Playing Field Study

Project Ref: 22315
ALA Project Ref: ALA823 New Woodley School
Client: Kirklees
Date: 21.01.2025

This letter provides a response to Sports England's comments on the planning application for a Special Educational Needs School (reference 2024/91998) at the Former Almondbury High School, Fernside Avenue, Huddersfield, HD5 8PQ.

DRAWING TITLE:
Landscape Illustrative Masterplan

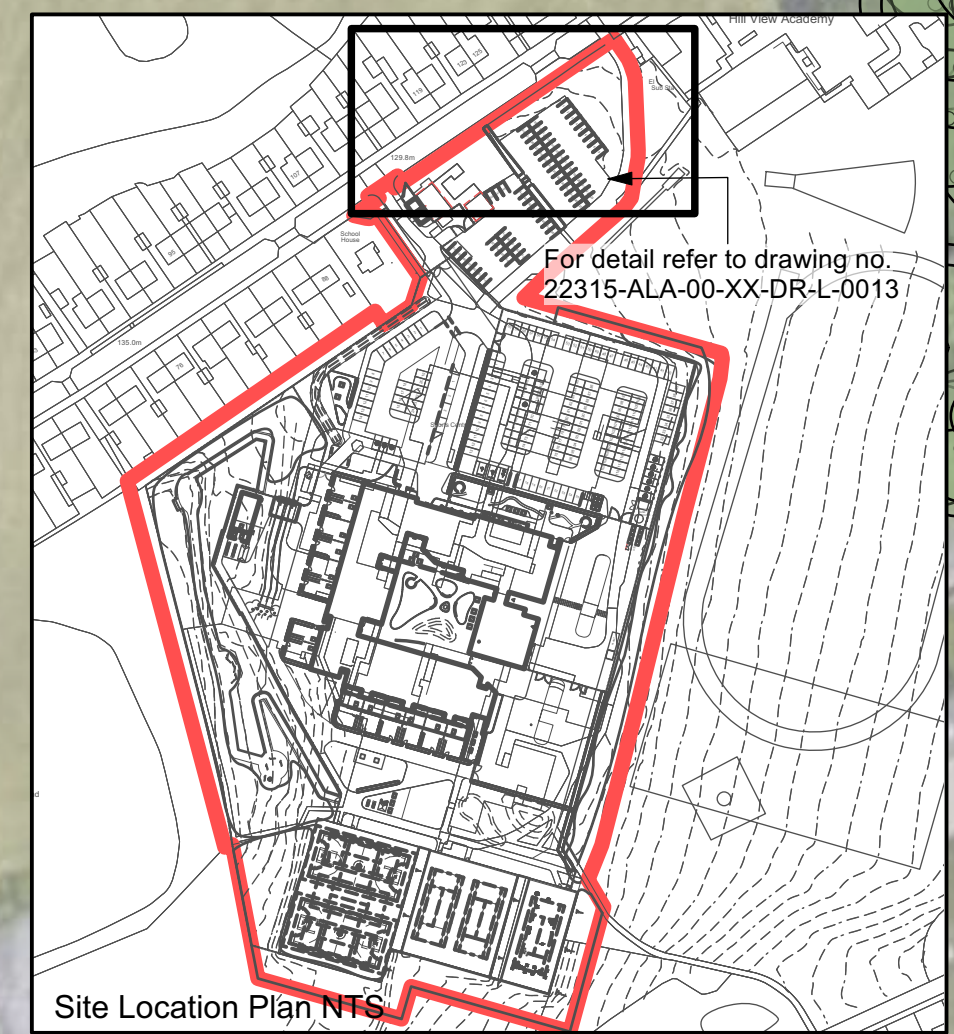
The submitted Illustrative Landscape Masterplan shows this area of the site used as a 'Forest School Play Space' which is a form of outdoor sports facility. This physical sporting activity is tailored to the specialist use of the site as a Special Educational Needs School for children and young people with Autism. This will provide a type of sporting activity that is significantly beneficial to children and young people with Autism.

Ball Stop Netting Layout

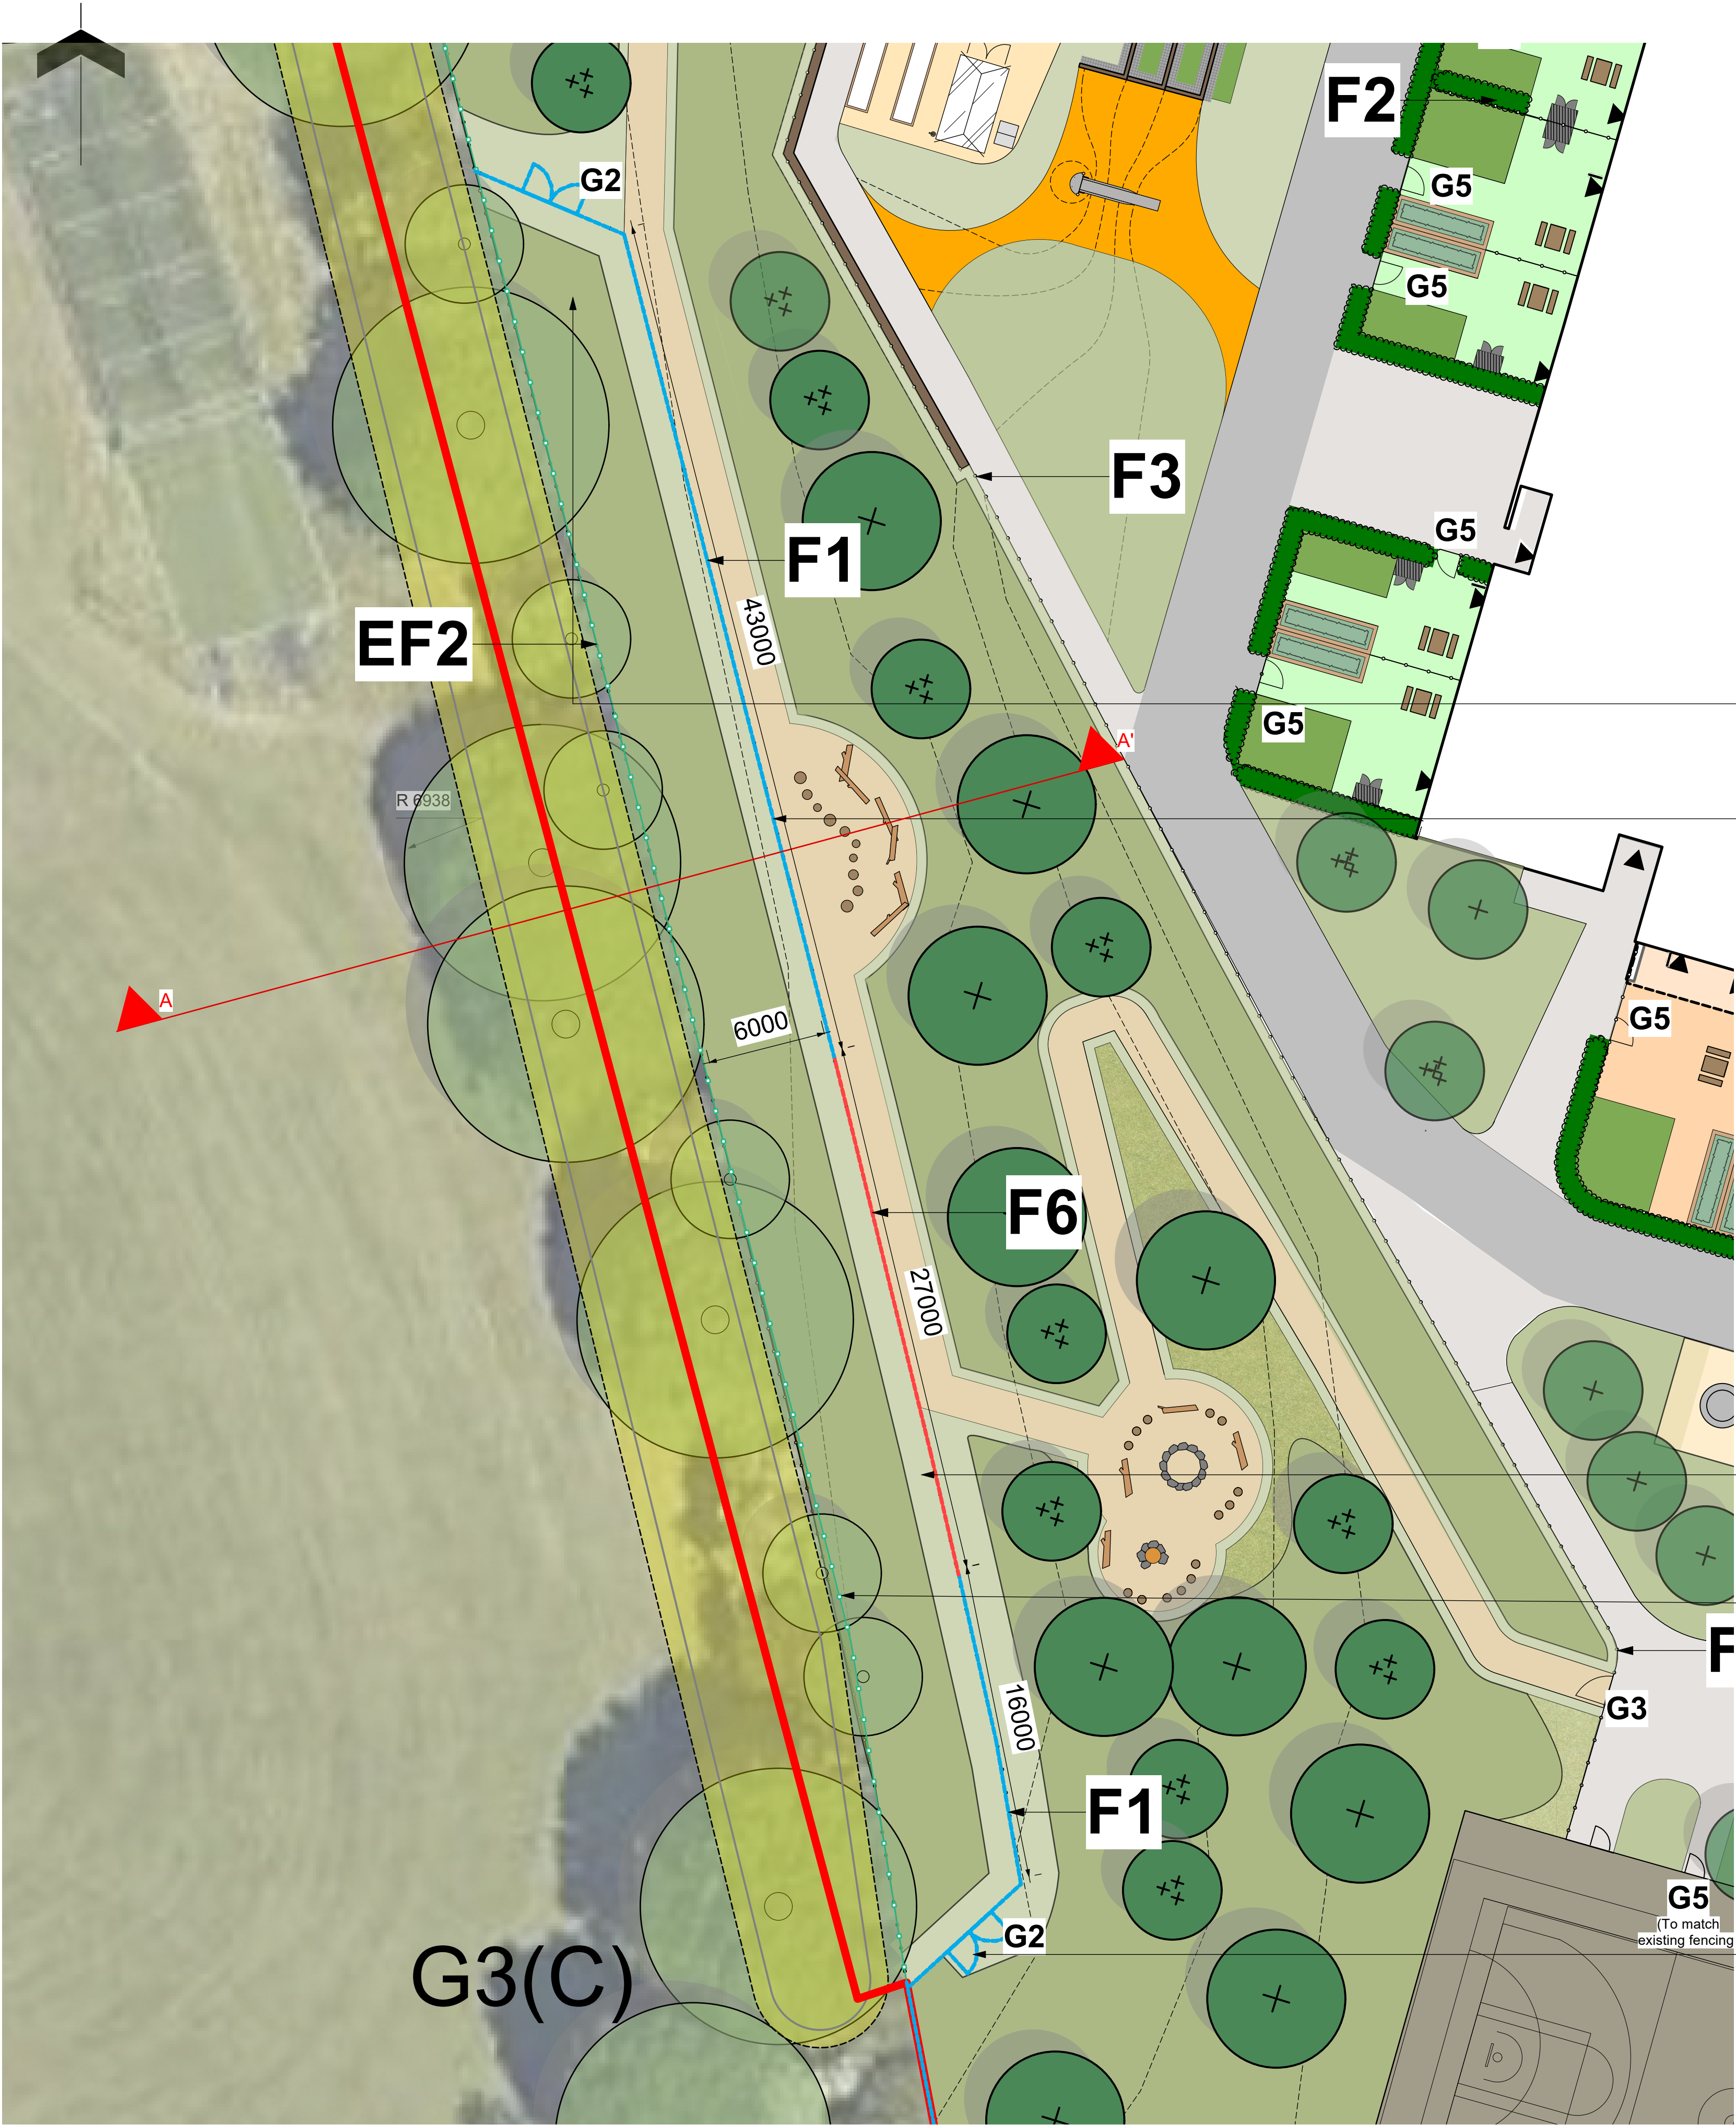
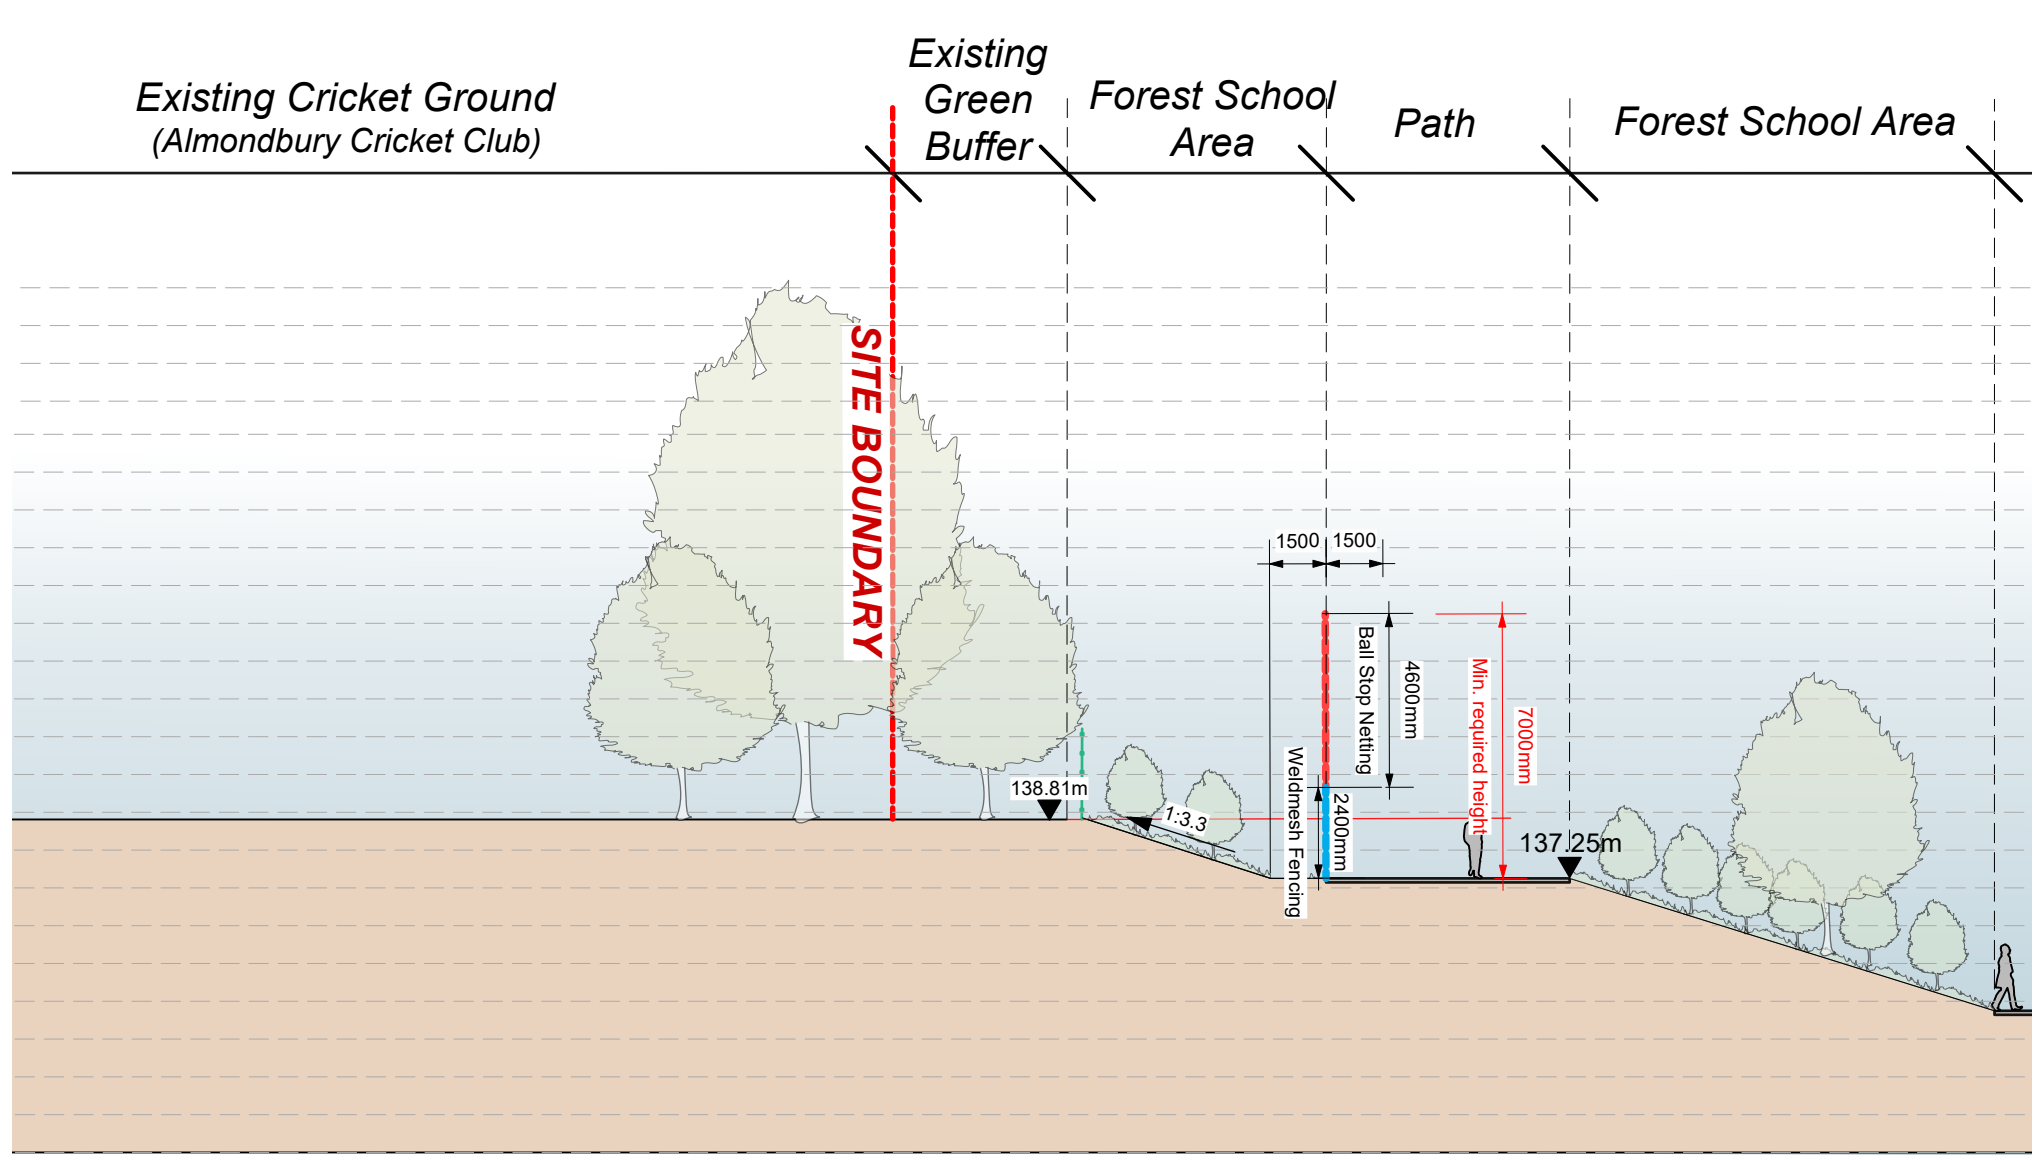
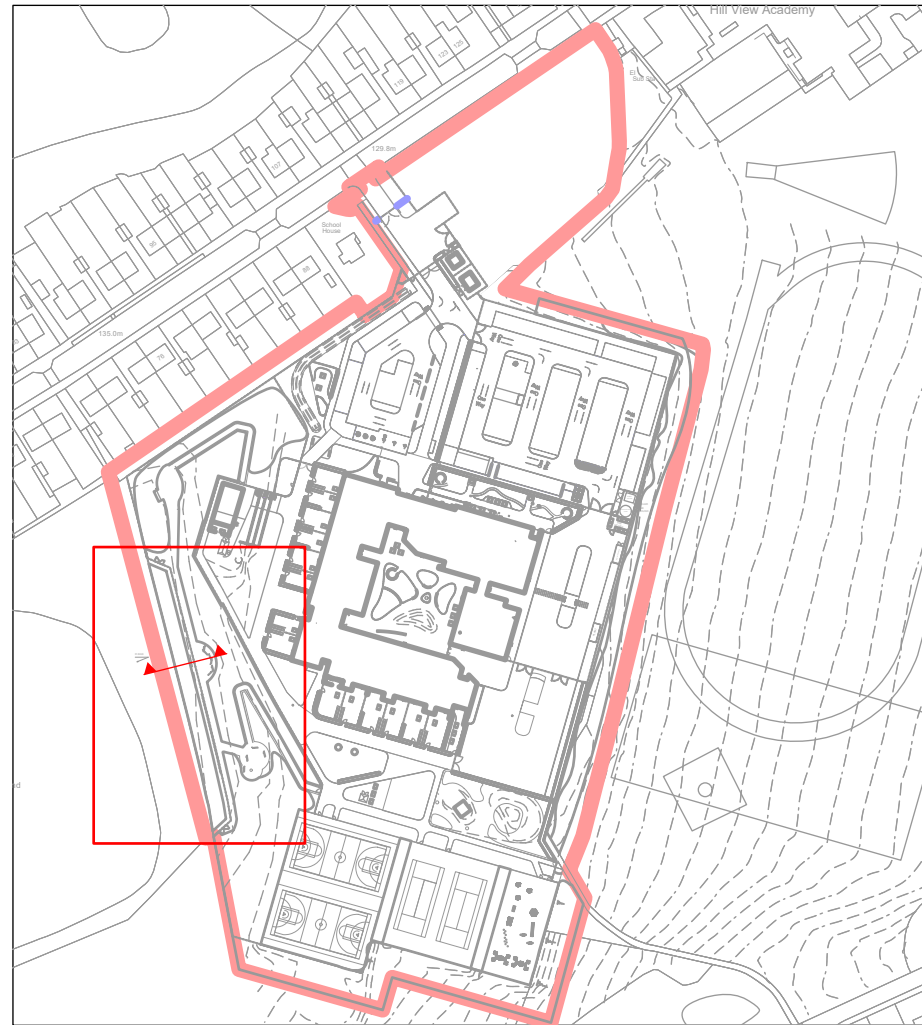
Point 4: Ball Strike

Response: A ball strike risk assessment has been undertaken by Labosport Ltd who have reviewed the site distances and topography to analyze the risk of balls surpassing the site boundaries of the cricket pitch at Almondbury Cricket Club.

The below diagram (Figure 8) shows the agreed proposed location of the recommended mitigation for a maximum height of 7m, offset from the boundary by 6m.

To be effective during all times of play when there is a risk of ball strike, no access is to be allowed into the area between the cricket square and the ball stop netting fence line.

A proposal has therefore been developed by Ares Landscape Architects which utilises 2.4m high weldmesh perimeter fencing to form the 2.4m boundary requirement (see Figure 9 and Figure 10 for illustrative layout and fencing plan), with retractable ball stop netting to be installed along the 27m extent to a height of 7m as required in Figure 8.

An access controlled area is therefore created between the ball stop netting line and the existing fence line which, available for maintenance to the fence line and vegetation when cricket is not in play.
